BOA228-Review #1 - 5/25/22 Planning
Please address the following items on your site plan:

For all submitted site plan drawings please add "PCD File No. BOA-22-008" to the bottom right hand corner.

PROPOSED USE SITE MAP

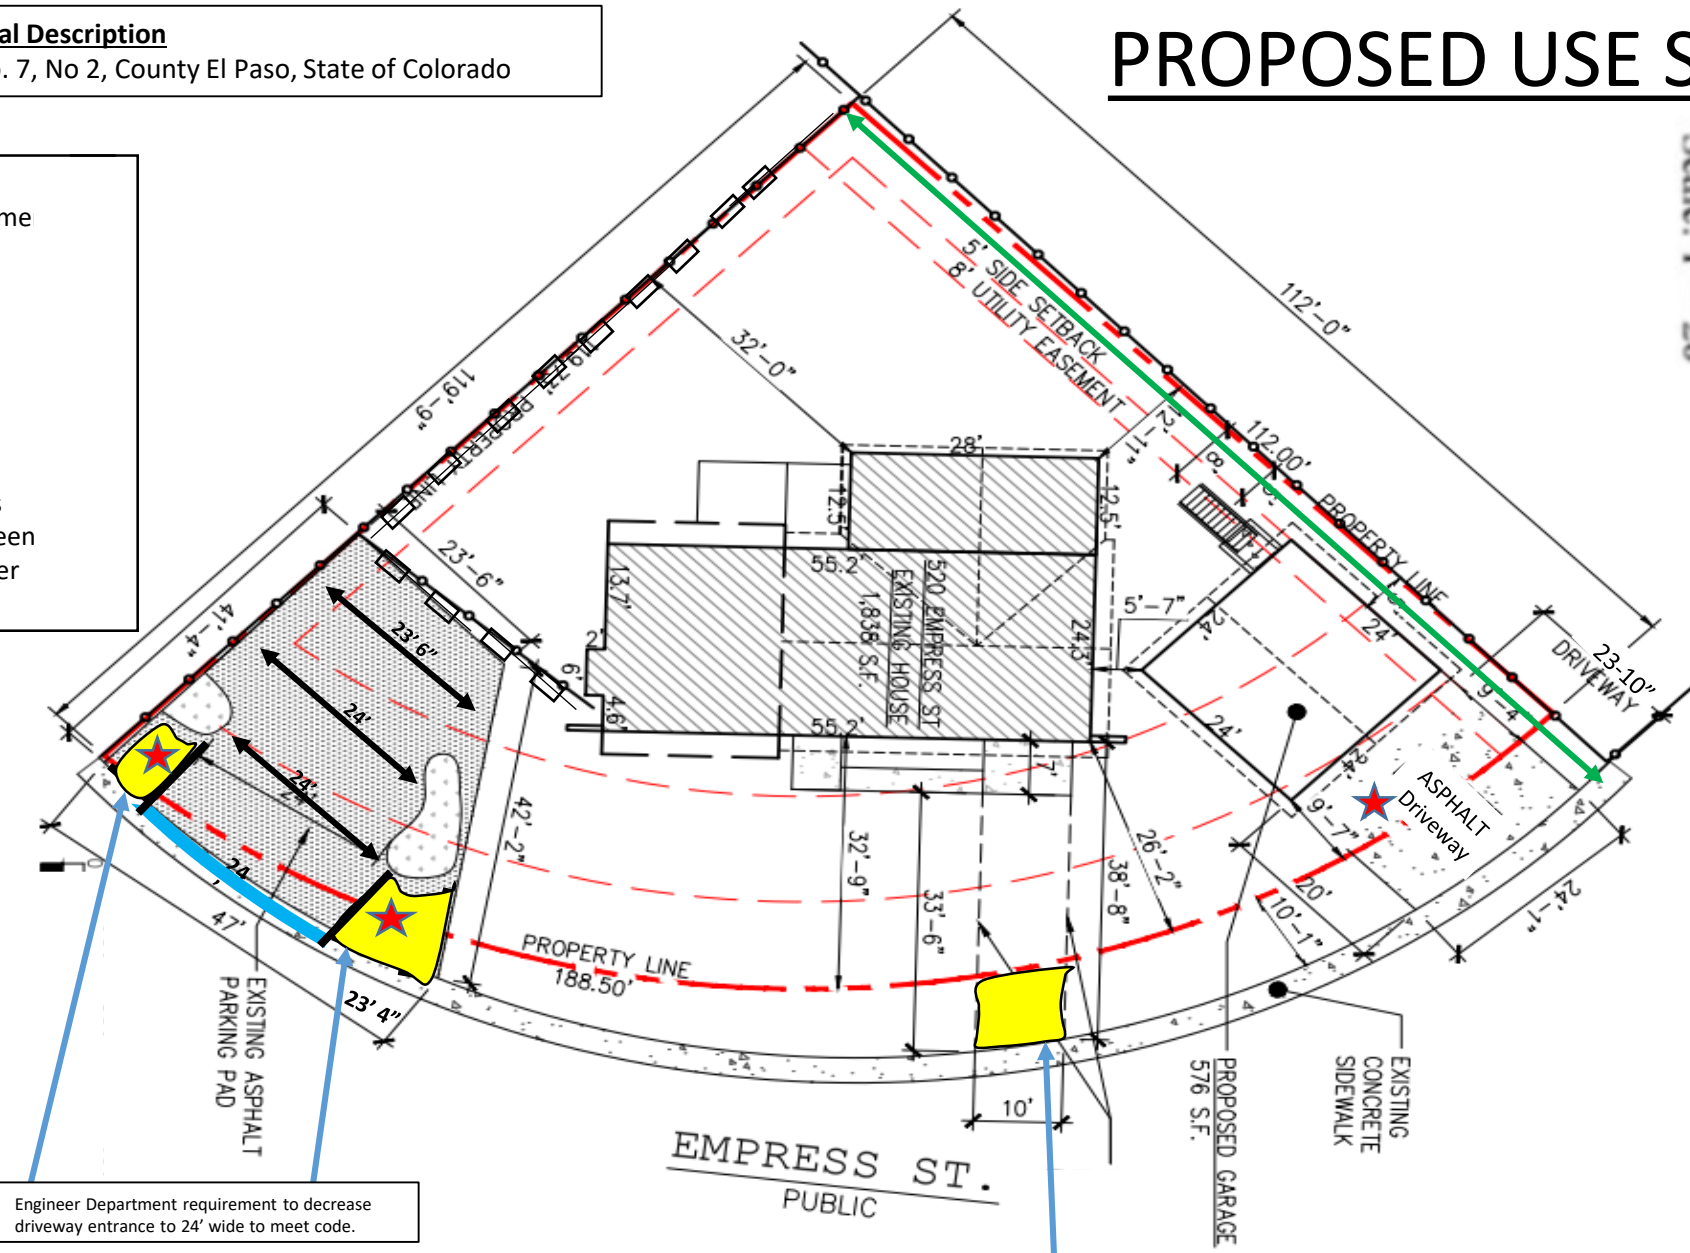
Per El Paso County Engineering Criteria Manual Chapter 2.4.1.B "accesses shall be separated by a distance equal to the entering sight distance values in Table 2-35." Per Table 2-35 for a two lane roadway with a posted speed limit of 25mph access shall be spaced a minimum of 250 feet for passenger cars.

- The parcel does not meet the criteria above for multiple access points. No new driveway access will be allowed for the proposed structure.

- Please show the proposed structure's driveway; proposed driveway should connect to existing driveway.

Please apply for a driveway access permit for the parcel's existing main driveway. Applicant will be required to close secondary access point. Additionally, no new driveway access will be allowed.

- Brief description of request
- The setback request on this sheet should match the letter of intent.
- Include setback requirements and what is being proposed. Include the side setback.
- Include proposed driveway location
- Include distance from the house to the proposed garage
- draw the 24'x24' garage to scale - it is a rectangle
- include the location and width of all sidewalks
- Include height of the proposed garage
- if applicable, indicate the location of existing and proposed water and wastewater infrastructure, including well(s) and septic system(s)
- if applicable, location of all no-build areas, floodplain(s), and drainage facilities
- Note the existing/proposed land use, parcel size, and zoning
